RYDE MEDICAL CENTRE  
SUBMISSION TO DEPARTMENT OF PLANNING  
GRAYTHWAITE PROJECT PART 3A ENVIRONMENTAL ASSESSMENT  
APPLICATION NO. MP10\_0179

**RE: RYDE MEDICAL CENTRE & GRAYTHWAITE REHABILITATION PROJECT –  
ACOUSTIC ADVICE**

**Geotechnical Review**  
**Ryde Medical Centre, Eastwood and Graythwaite Rehabilitation Centre, Denistone**

01 WEST ELEVATION
SCALE 1:200

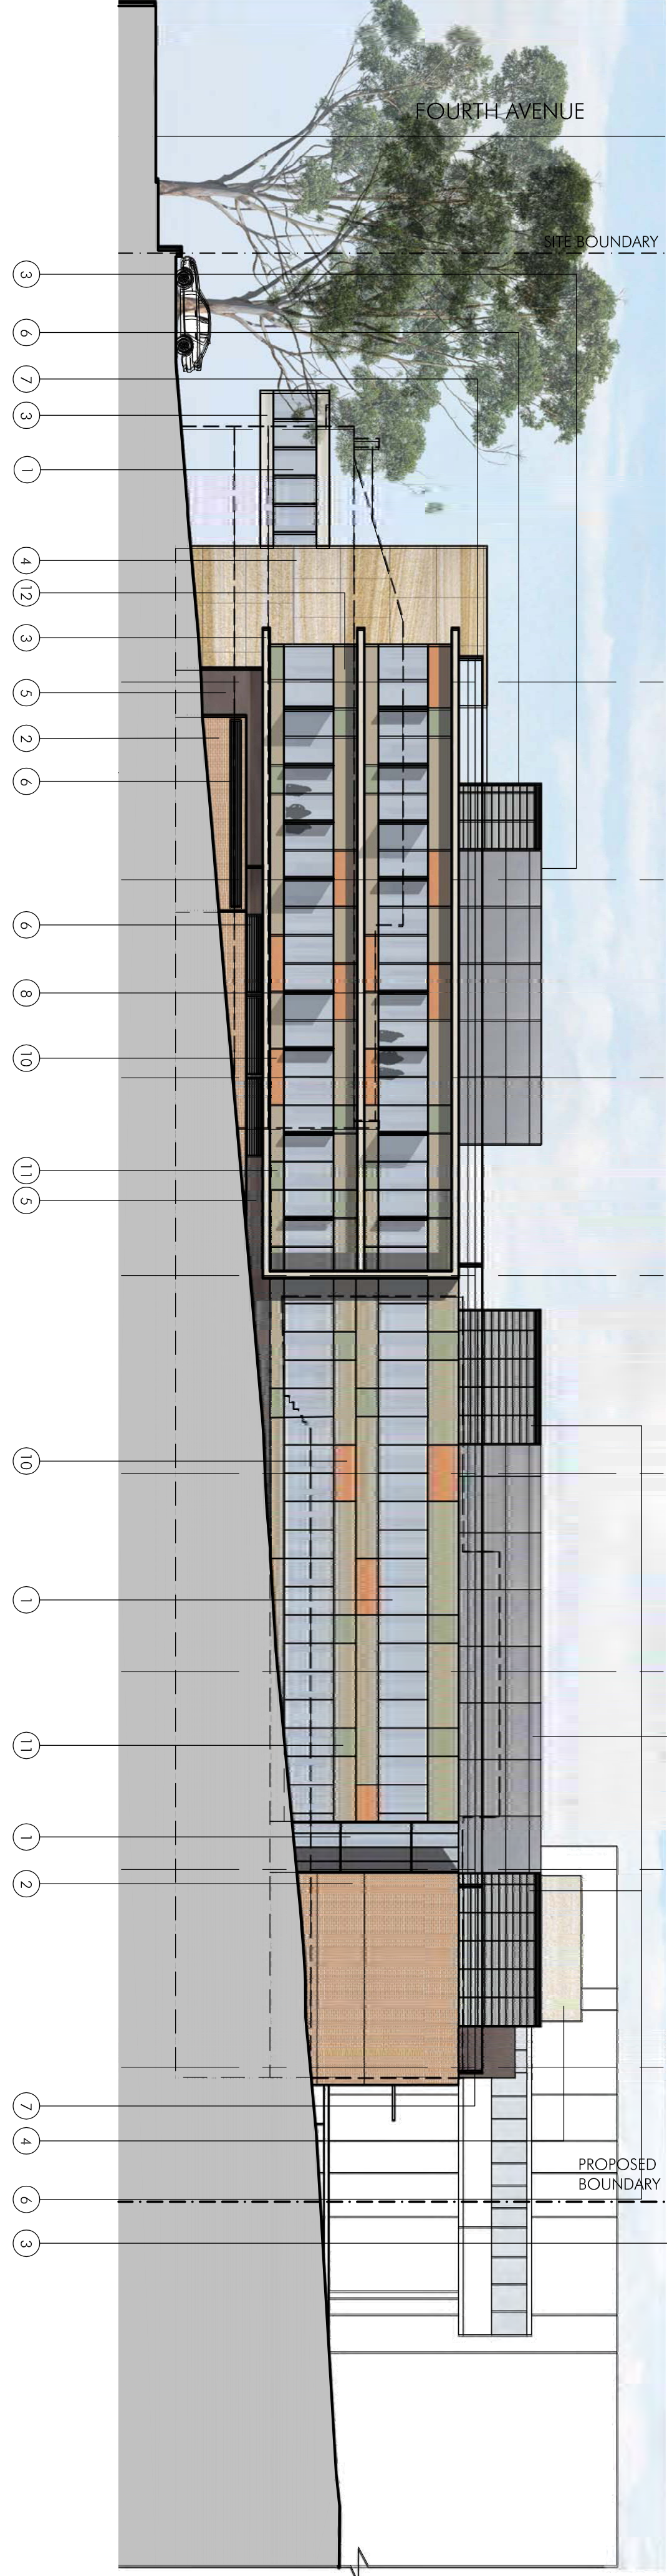
- (a) Generator room located adjacent to Ryde Medical Centre boundary (ground floor plan between gridlines A-B and 1-2 to be designed with appropriate wall constructions, acoustic doors and seals so that noise emissions do not exceed the set noise goals at the boundary (set noise goals to be defined).

- (b) Noise mitigation to be installed to the mechanical plant on the rooftop or install acoustic screens along the western side of the plant area.
- (c) Conduct a detailed review of mechanical plant noise emissions once plant selections on locations are finalised including in determination as to the height and extent of the proposed screens around the rooftop plant to ensure satisfactory acoustic control and to determine whether some of the louvred sections of the enclosure should be changed to screens.
